Application for Planning Permission

Development: Changes to the parking layout with the addition of new grasscrete parking areas to the north and south sides of the building, which has permission to be used as a funeral chapel, to increase parking provision to 22 spaces (including a disabled space), and for improved hearse access, fencing to side boundaries and replacement planting to north side. This application may affect the setting of a listed building and is in CIL Zone 4 (Zero Rated) as other development.

Location: The Former Conservative Club 41 Sea Road East Preston BN16 1JN

SOUTHERN FENCE ELEVATION 1:100 @ A3 (View 'A')

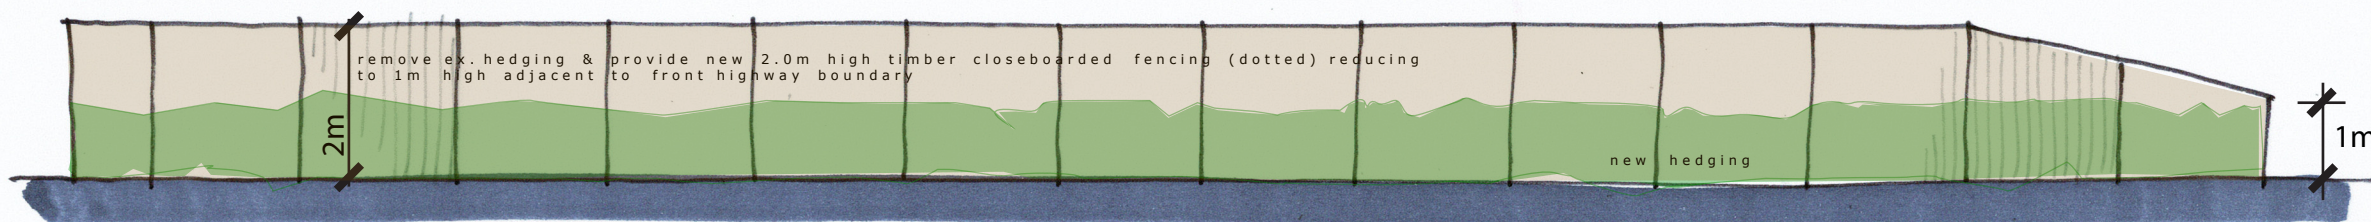
Please provide an elevation, to scale, for the proposed fencing.
